Application Ref:	3/2026/0161				Ribble Valley Borough Council www.ribblevalley.gov.uk	
Date Inspected:	01/04/2026	Site Notice:	01/04/2026			
Officer:	MC					
DELEGATED ITEM FILE REPORT:					REFUSAL

Development Description:	Enlarged Glazed Window Opening
Site Address/Location:	The Hey, Cutler Lane, Chipping, Preston, PR3 2SY

North East Elevation

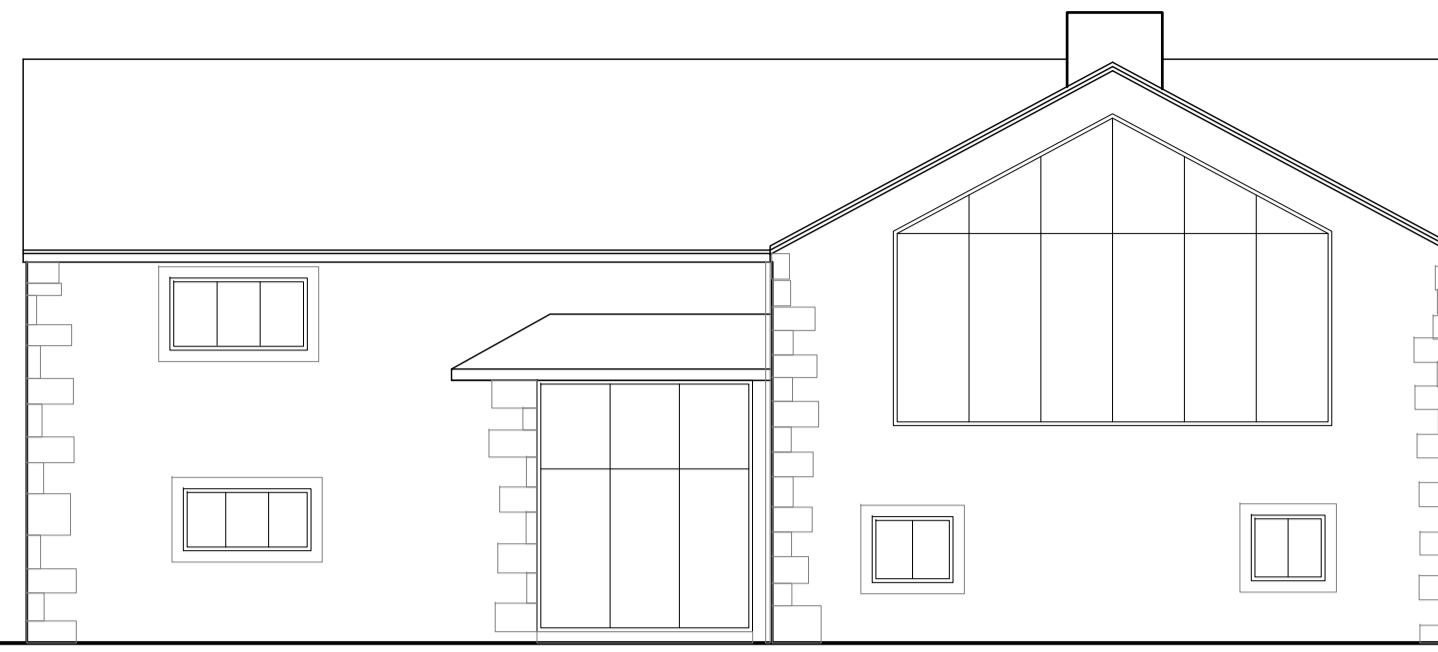
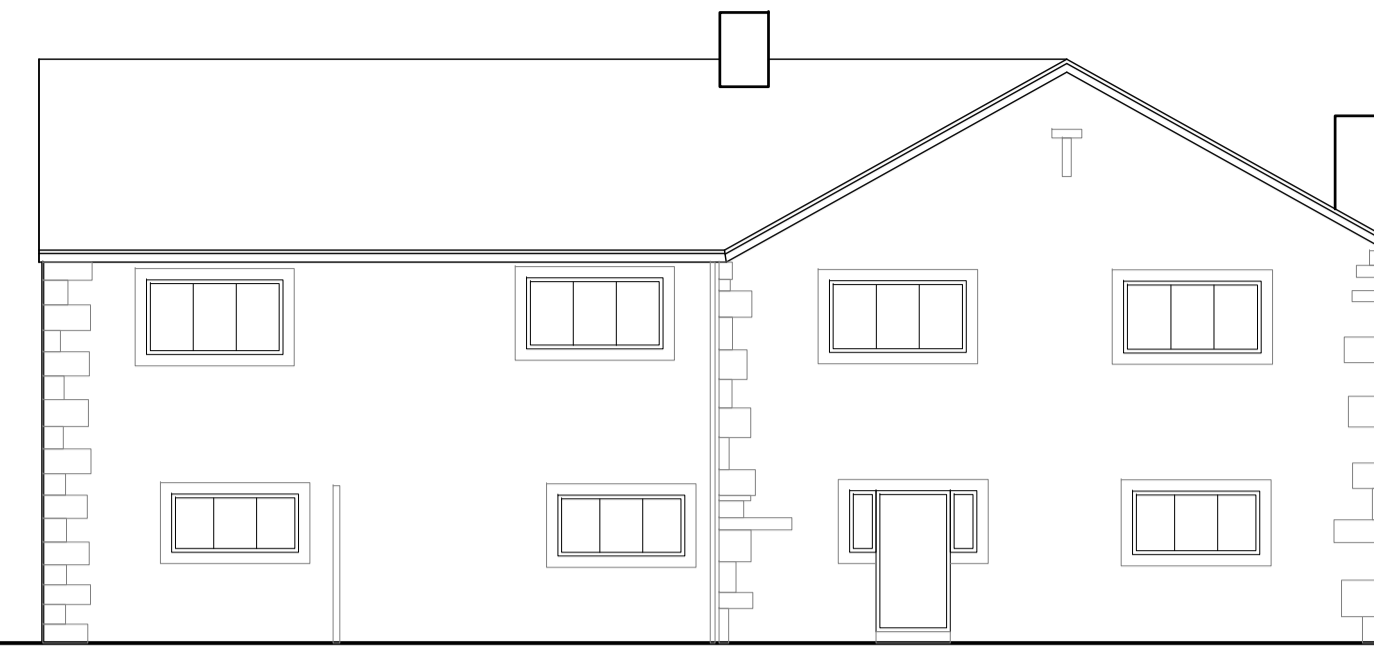
The proposed development is for the enlargement of an existing window opening to the Northeast elevation of the building. The proposal would include a large expanse of glazing, extending close to the roof apex at first floor level.

The barn conversion is fairly traditional in character, with a traditional glazed cart lodge to the northeast elevation which is the same elevation as the proposed new window. The new window would extend high up into the apex, with extensive glazing, covering the majority of the first floor of the gable projection and is considered to be excessive in size and scale. The amount of glazing would compete with the cart door glazing and would diminish this feature which makes a positive contribution to the converted barn.

As such, it is considered that the size, scale and design of the proposed window enlargement would introduce an overly large and modern addition to this elevation of the converted barn, which is considered to harm the character and appearance of the barn and fails to be in keeping with the character of the landscape of the Forest of Bowland National Landscape.

The proposed window enlargement due to its size, scale and design is considered to result in an overly excessive amount of glazing which would fail to be in keeping with the character and appearance of the existing converted barn, resulting in harm to the character and landscape of the Forest of Bowland National Landscape contrary to Key Statement EN2 and Policies DMG1, DMG2 and DMH5 of the Ribble Valley Core Strategy, as well as paragraph 135, 187 and 189 of the National Planning Policy Framework.
